From: Jez Lye [REDACTED]
Sent: 05 July 2017 17:51
To: Anita Gardner
Subject: Re: AB/40/17/L Provision of first floor window

From: Anita Gardner
Sent: 26 June 2017 14:28
To: [REDACTED]
Subject: AB/40/17/L Provision of first floor window

DRAWING TITLE
EXISTING & PROPOSED
ELEVATIONS

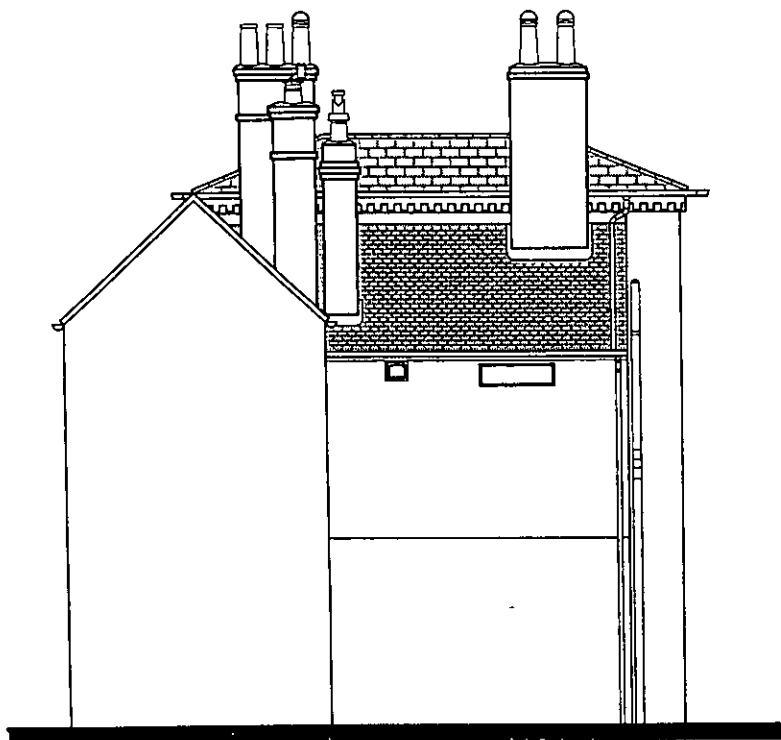
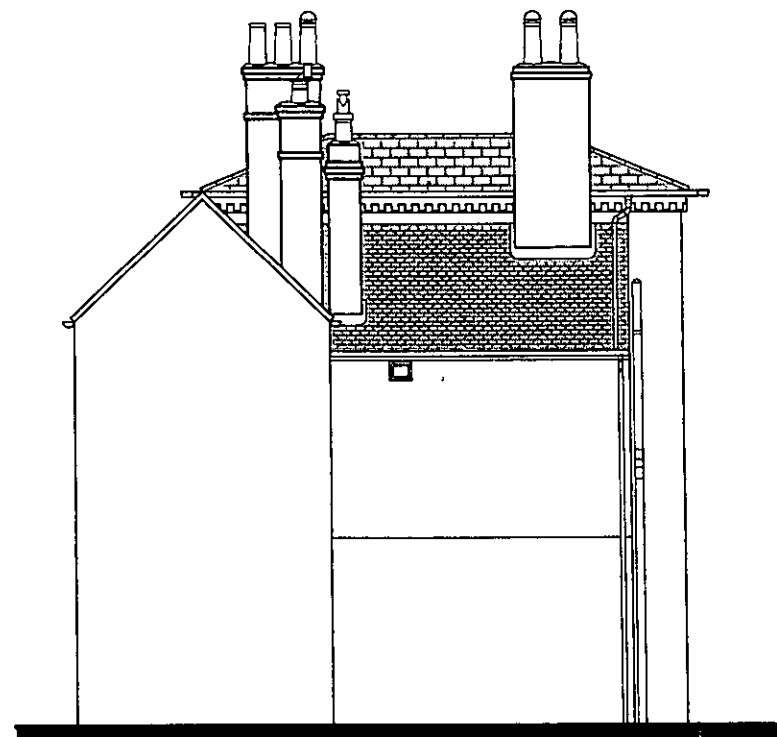
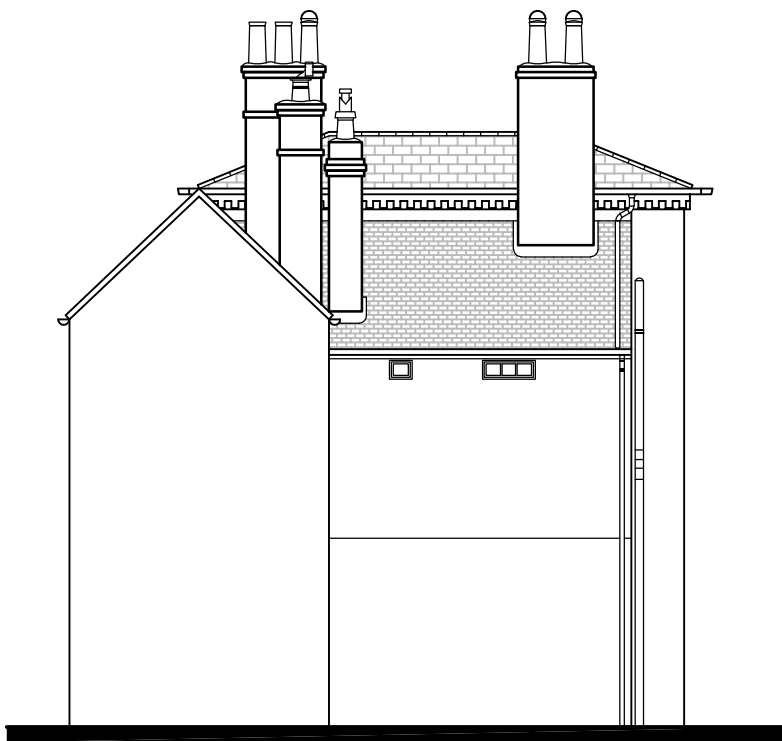
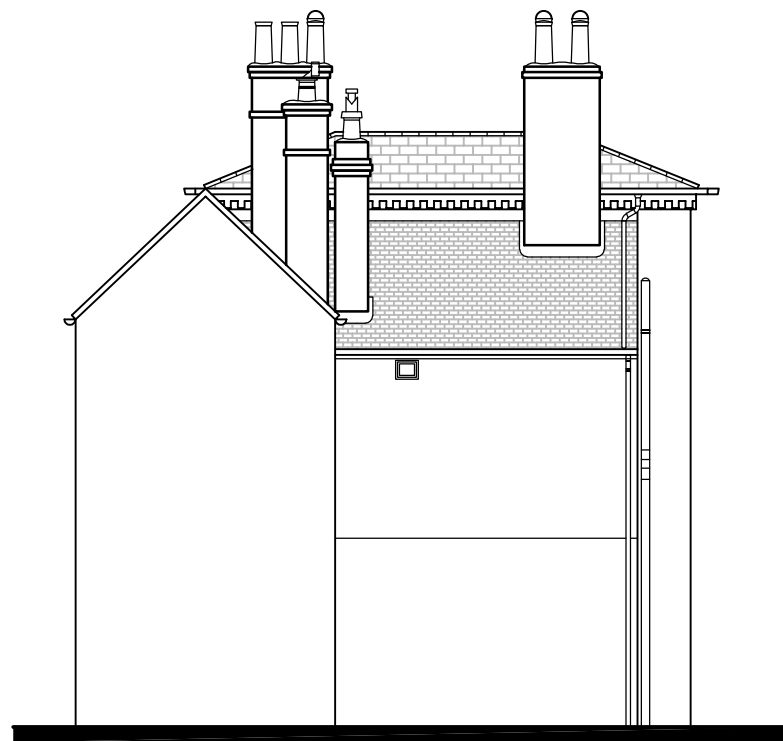
I refer to the above application and can advise that I have now received the comments of Dr Wightman, the Historic Building Adviser. He considers the principle of an additional window is fine, but has concerns that the design as submitted is not sympathetic. It is far too modern in character.

Without prejudice, I would therefore appreciate receipt of a revised elevation plan to indicate an opening of more appropriate design within the next 2 weeks. I would also be grateful if you could agree to an extension of time on the application, to allow time for receipt of plans and re-consultation, of one month until 26-07-2017 to facilitate this.

Herewith revised drawing showing the new window with glazing beads and same surround as existing small window in adjacent bathroom.
